Application No: R/31/26/HH
Site Address: 15 Evelyn Avenue Rustington BN16 2EJ
Description of works: Single storey front porch and rear extension to replace the existing conservatory, proposed hip to gable extensions, a rear dormer, roof lights and side windows with obscure glass.

Thank you for your internet representation made on 14th March 2026 which has been recorded as an objection with the comments as follows:

planning application ref R/31/26/HH

Rev	Notes	Date
 M: 07599199759 E: info@nat-design.co.uk www.nat-design.co.uk		
Project:		
15 Evelyn Avenue Rustington BN16 2EJ		
Drawing:		
Proposed Elevations		
Drawn by NSE		Scale as shown
Date Feb 2026		Revision
Drawing		
2027 - DPA - 06

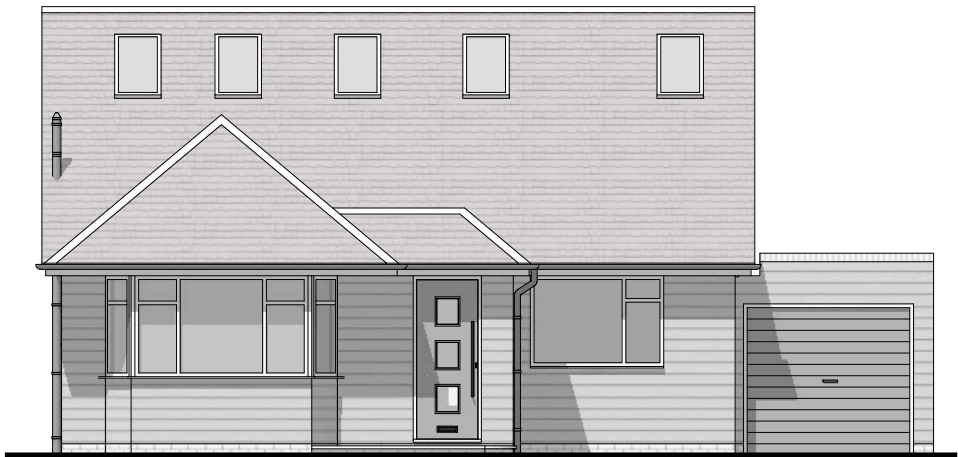
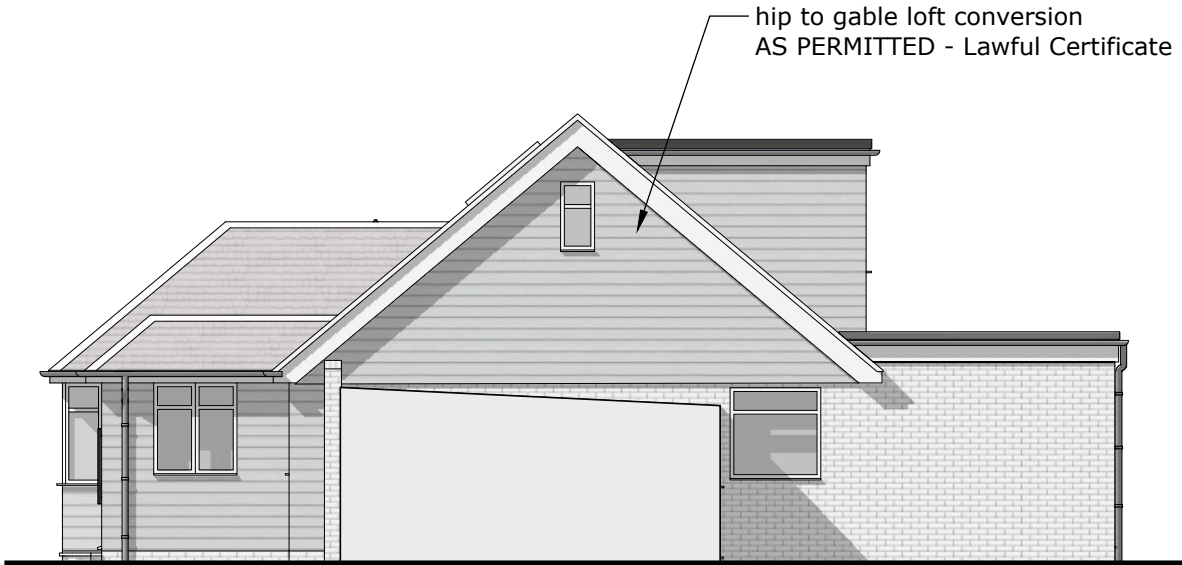
The proposed development appears significantly larger and higher than the existing structure and would be likely to reduce natural sunlight and daylight to neighbouring properties. Due to the proximity and height of the proposed two-storey building, it is likely that the development would breach the commonly applied 45-degree daylight guideline used by many planning authorities to assess loss of light to neighbouring properties. This suggests that the proposal may cause unacceptable loss of daylight to the neighbouring bungalows.

The proposed development would introduce a building that is noticeably different in form and mass, disrupting the established streetscape.

The use of external cladding as proposed would appear visually out of place in the context of the surrounding houses, which predominantly feature traditional brick or rendered finishes. The properties that do have some cladding only have a small section of decorative cladding on the front elevation. As I understand it the proposal is to have large sections of the property covered in cladding. This material choice would therefore detract from the overall appearance and character of the street.
